**From:** Peart, Timothy - Communities <Timothy.Peart@Oxfordshire.gov.uk>  
**Sent:** 07 October 2020 12:16  
**To:** Rebekah Morgan  
**Cc:** Nick Jones-Hill; Manku, Amrik - Communities; White, Joy - Communities  
**Subject:** FW: A41 Roundabout - Response to OCC  
**Attachments:** WIE11386-145-03-001-A41 Pioneer Rbt General Arrangement - A03-A1.pdf

**From:** White, Joy - Communities  
**Sent:** 01 October 2020 17:47  
**To:** Rebekah Morgan <[rebekah.morgan@cherwell-dc.gov.uk](mailto:rebekah.morgan@cherwell-dc.gov.uk)>; Nick Jones-Hill <[nick.jones-hill@watermangroup.com](mailto:nick.jones-hill@watermangroup.com)>  
**Subject:** RE: A41 Roundabout - Response to OCC

Drawing 3: Proposed Site GA Plan (Drawing ref. WIE11386-145-03-001)

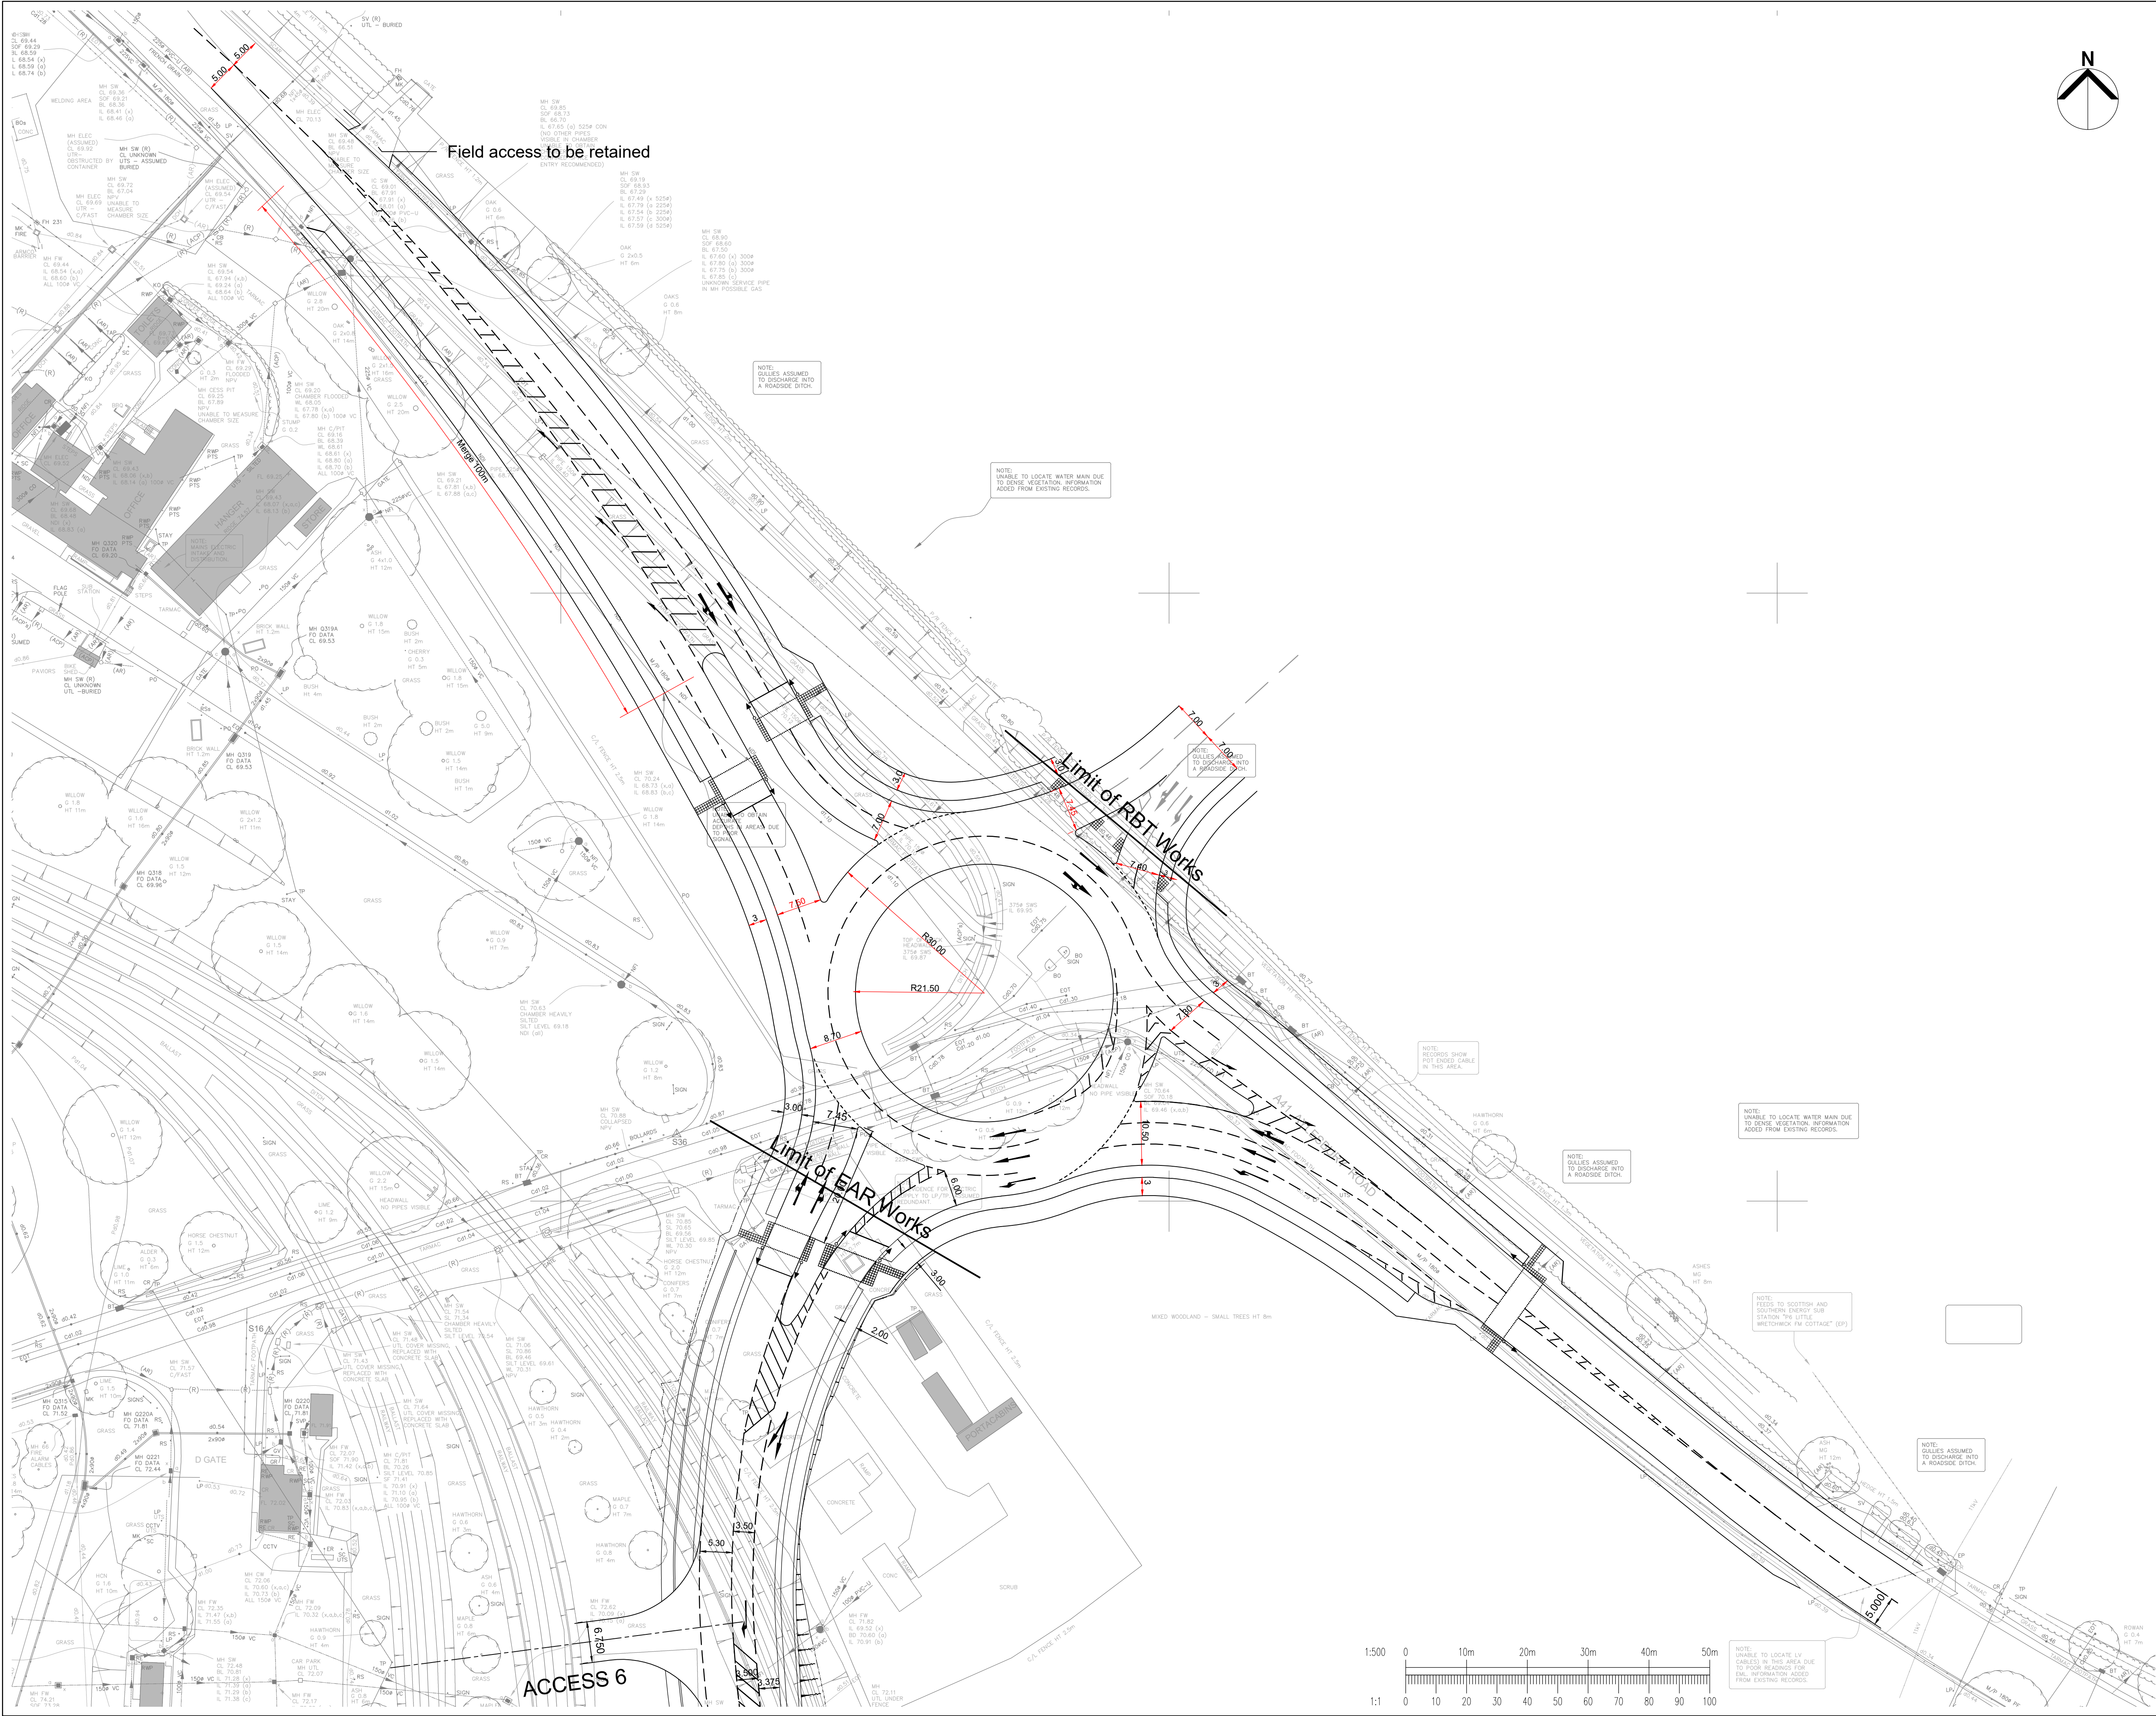
We welcome the segregation of the cycle and footway around the roundabout. It is unfortunate that the additional width required has reduced the verge width, but I assume that is because of the restriction of the red line boundary of this planning application - the red line is adjacent to the back of the cycleway. It may be possible to increase the verge width on the northern side immediately adjacent the roundabout - this is a detail that could be agreed at S278 submission stage.

We also welcome the efforts to avoid the staggered crossing. However, the segregated cycle and pedestrian crossing on the western arm does give us cause for concern. We recognise that this form of crossing is set out in LTN 1/20 but is more suited to crossings at signalised junctions, and it removes the stagger for cyclists. At a standalone crossing (which this is, because it is not linked

to signalised operation of the roundabout) there is more scope for driver confusion over the two separate crossings. Pedestrians would also be likely to use the cycle crossing if it allowed a crossing in one operation as opposed to the staggered pedestrian crossing next to it. We have concerns about the length of time that traffic would be stopped on a red signal to allow a safe pedestrian crossing of all lanes in one movement, which would likely cause traffic to back up to the roundabout at busy times. At a signalised junction, this time can be better accommodated in the phasing of the lights.

There is scope for a shared pedestrian/cycle crossing not to be staggered and still have to be crossed in two stages. However, the Traffic Signs Manual recommends a wider refuge. I do not consider the proposed refuge would be wide enough to avoid the possibility of a pedestrian mistakenly thinking they can cross in one stage, which would be a safety risk. However, if it is not possible to widen the refuge, it may be possible to reduce the stagger shown to a slight offset.

In summary, whilst we have concerns with the design of the crossing on the western arm as shown, there may be scope to find a solution at the detailed design stage, which reduces the stagger of the crossing in line with updated LTN 1/20 guidance. However, given our concern over the separate cycle crossing at this location, we would prefer the amended plan not to be approved. Our preference would be for a plan which shows the segregated cycle path, but the crossing as per the original plan.

I can confirm that the attached drawing (ref: WIE A41 03 001 A03) addresses the concerns raised in Joy White's consultation response dated 3 September 2020 and the points raised below.

The county council has no objection to the general arrangement as shown in the attached plan. The detailed design will be subject to a full technical audit and approval process at the S278 stage.
